# DEVELOPMENT FACILITATIVE TEAM (DFT)

**PR-2022-007805** (Second Submittal)

SI-2024-00849 – SITE PLAN DFT

**Project Name:** *Roses Southwest Papers – Crick Crossing between Watson SE and Hawking SE*

A1 SITE PLAN - DFT
SCALE: 1" = 80'-0"

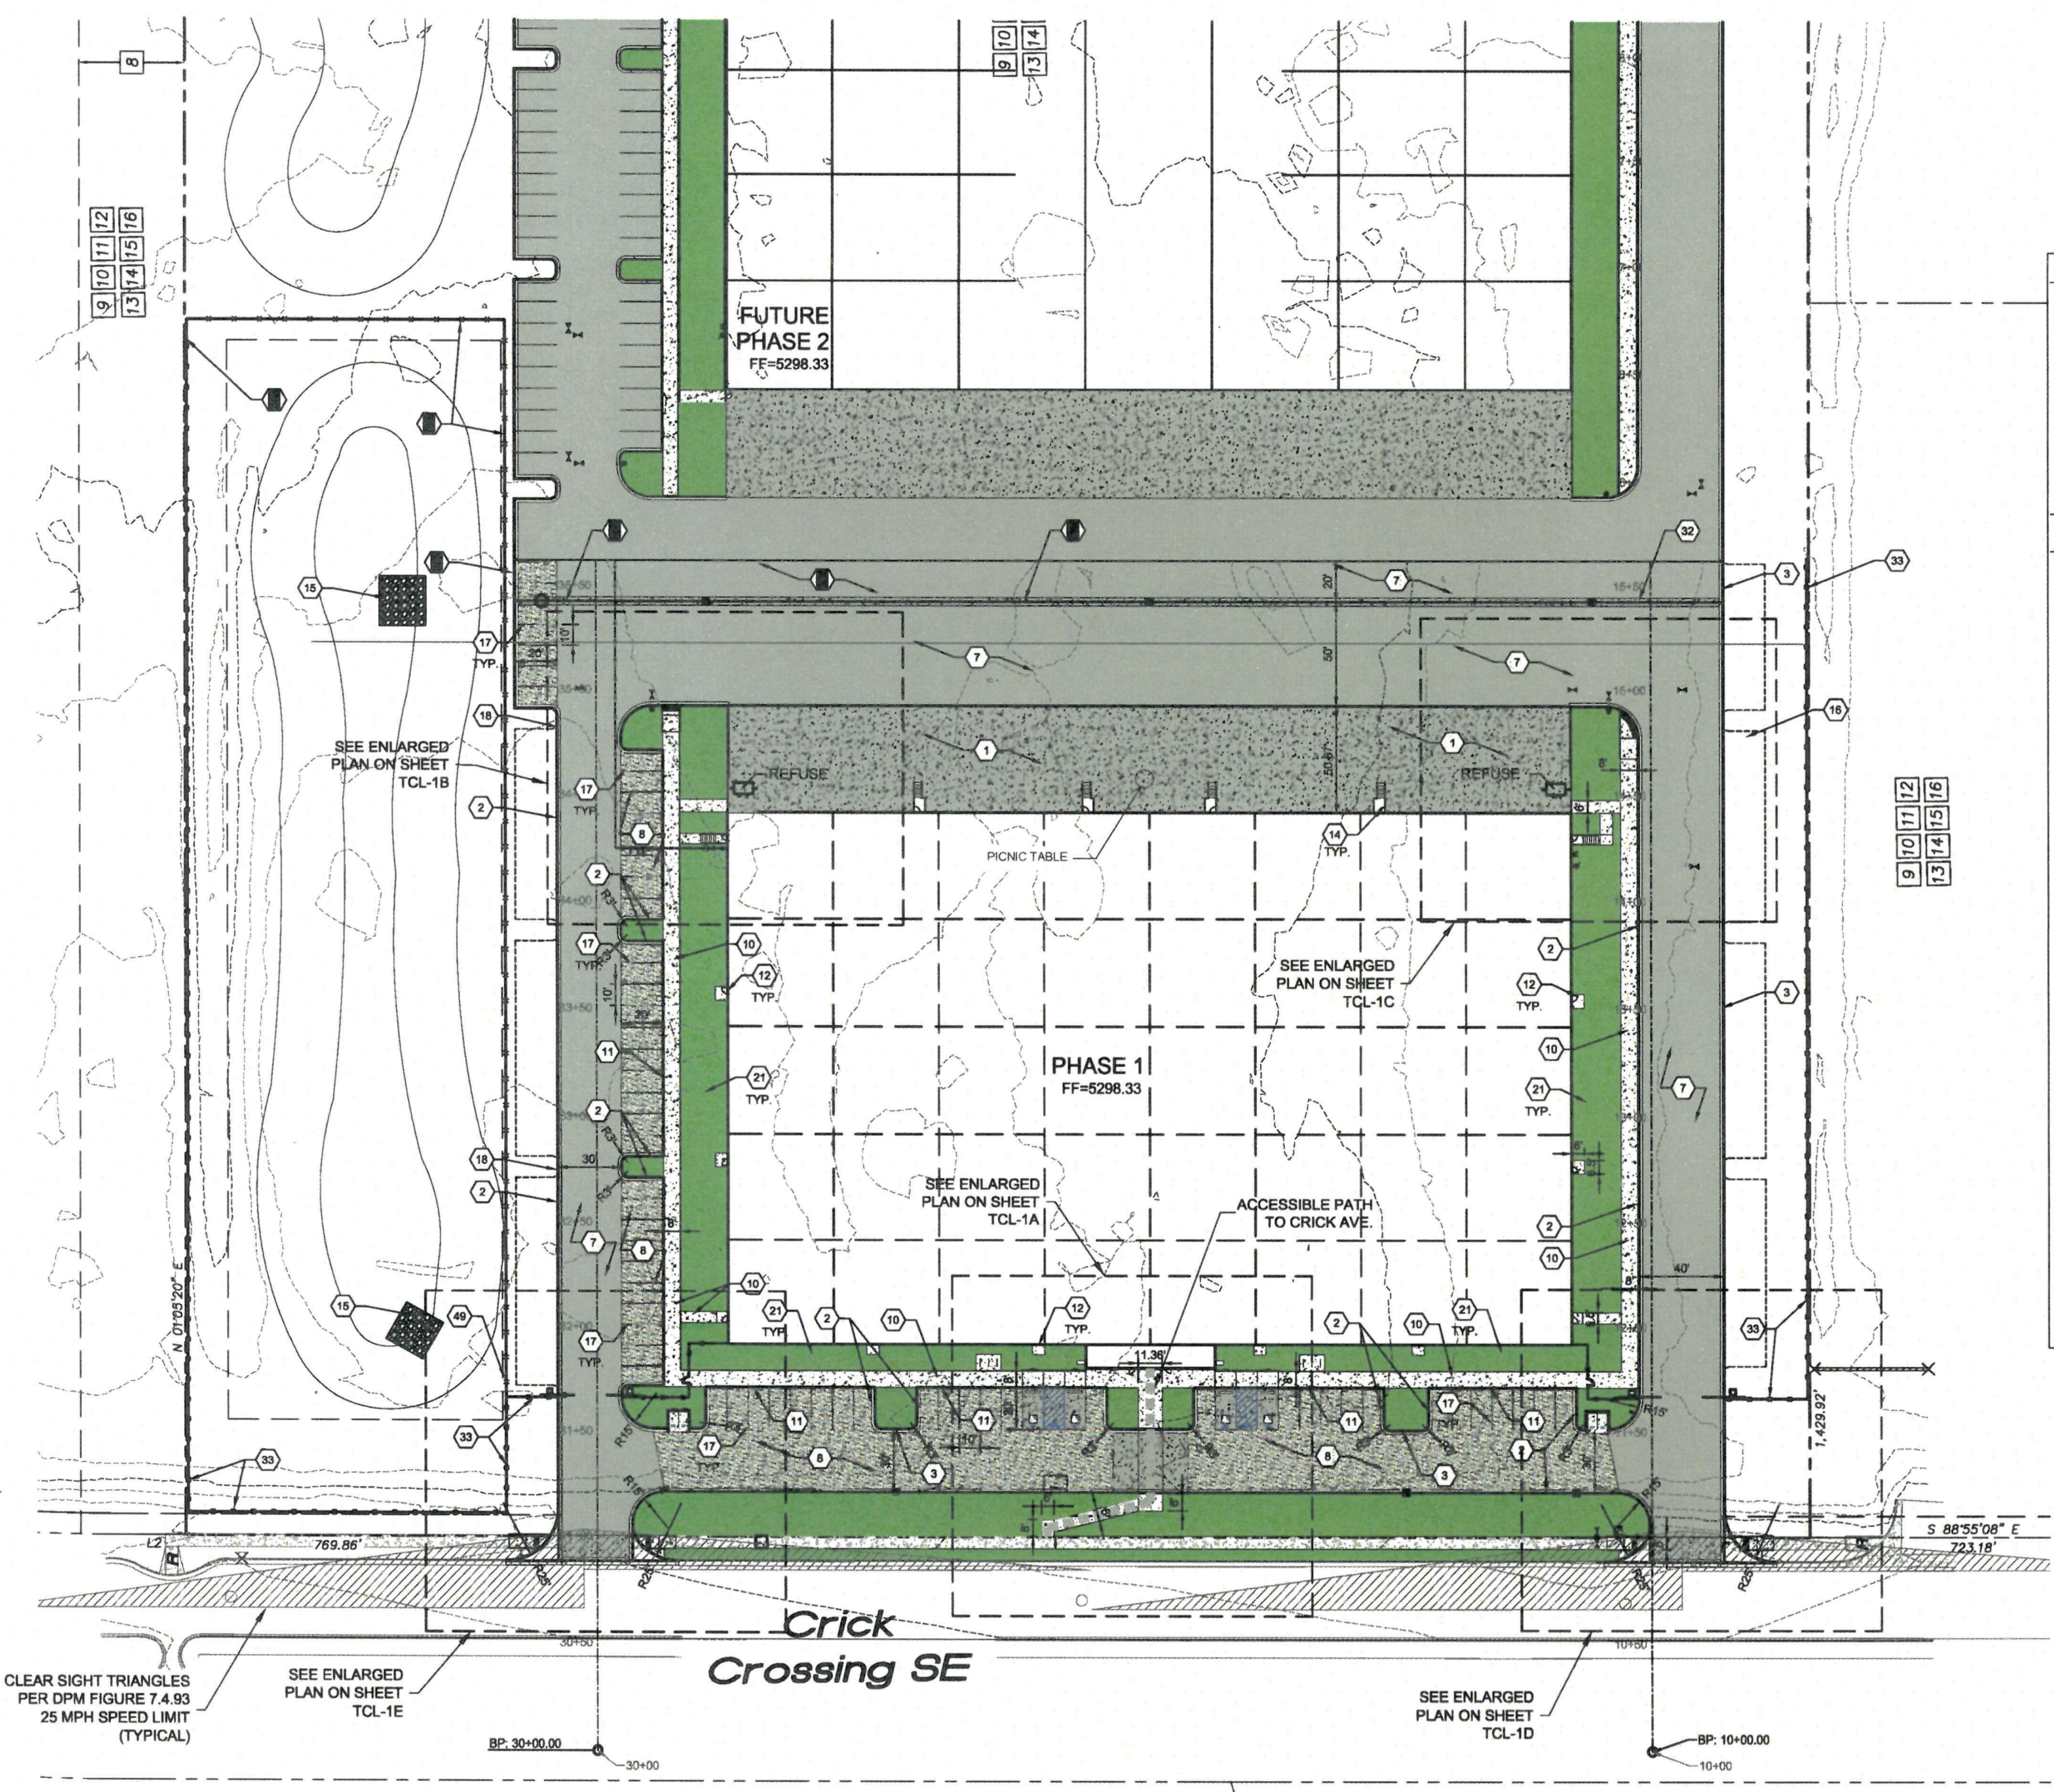
- The applicant proposed three project phases on the one lot, but is only detailing phase one in this site plan submittal. Therefore, future phases must have site plan approval processed as a Major Amendment to this site plan. Place the following note next to each future phase:

**'Future Phases II: Must be approved as a Major Site Plan Amendment'**

**'Future Phases III: Must be approved as a Major Site Plan Amendment'**

- Site Plan sheet seems to be missing from the set. Provide a Site Plan including the project data and calculations, and with a DFT signature block. Site plan sheet has been provided.

#### c) Maximum site FAR: 4.0 **Data must be provided on the site plan sheet.**

Applicant had added these notes to the site plan.

**FAR 0.27 for first Phase. Added to Site plan.**

A1 FIRE 1 PLAN - PHASE 1
SCALE: 1" = 40'-0"

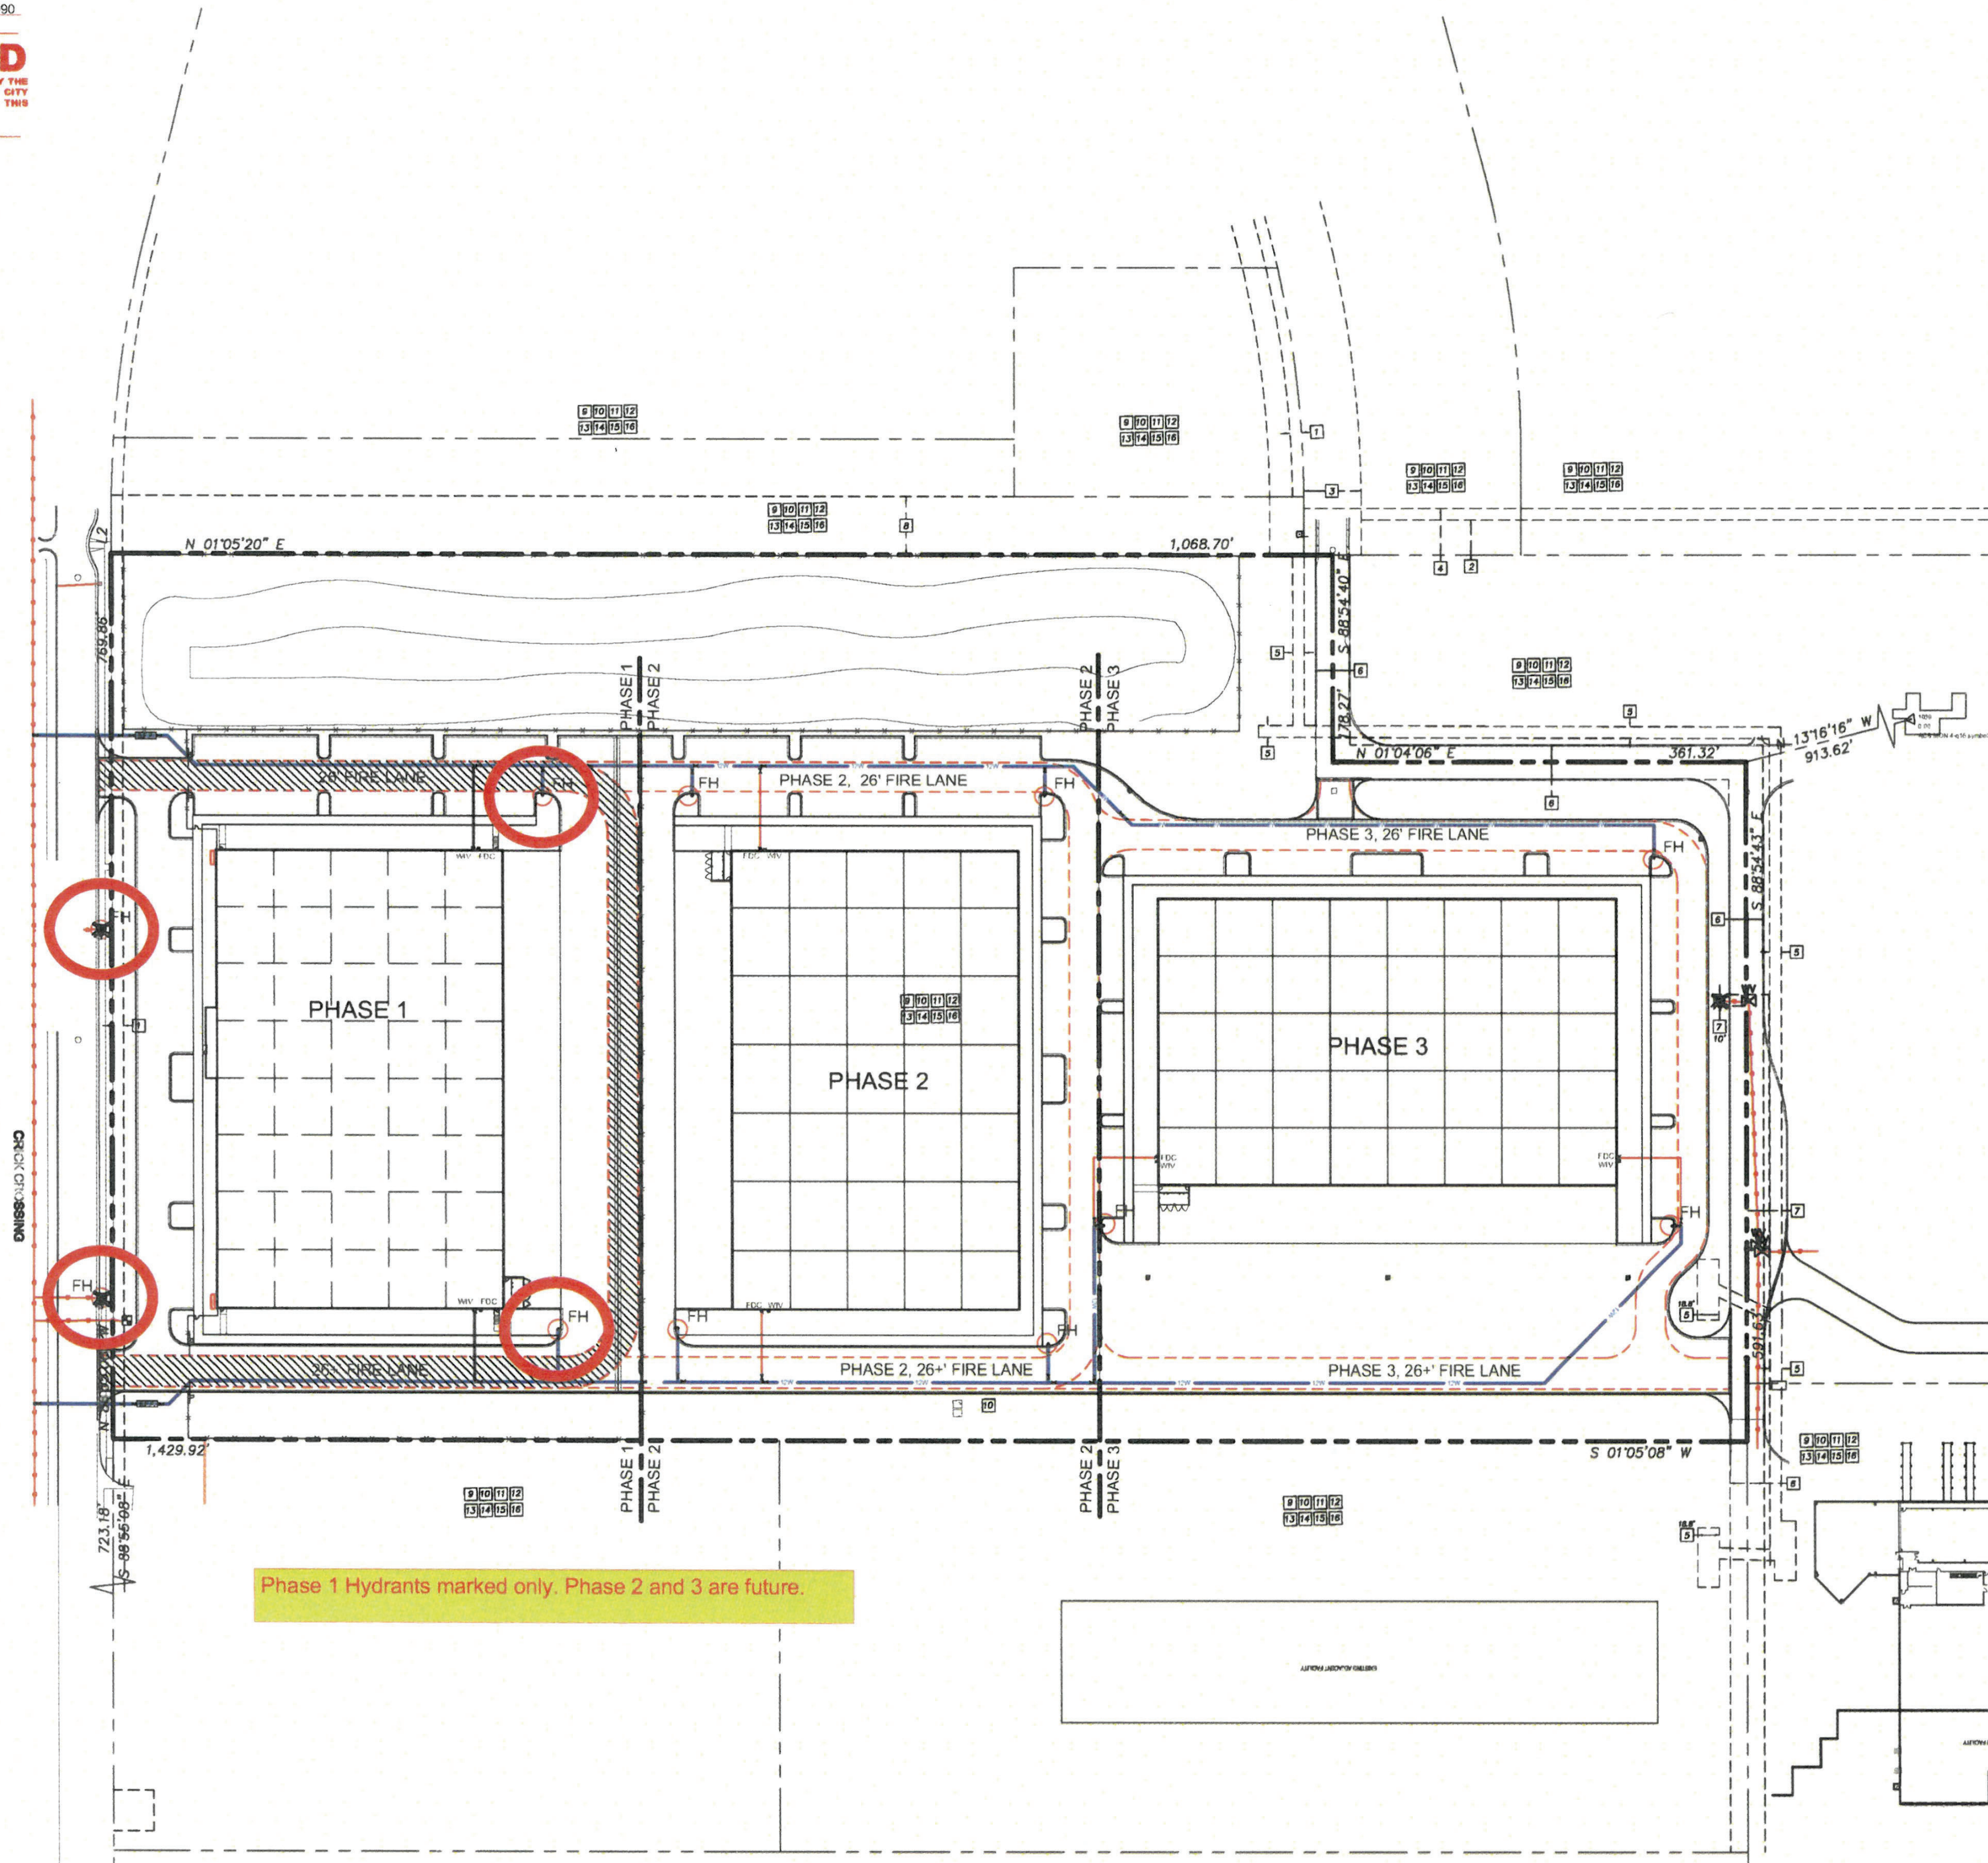
- All plan sheets must be signed and sealed by a professional licensed in the state of New Mexico. Fire one plan is not showing any signature and seals. Stamp added.
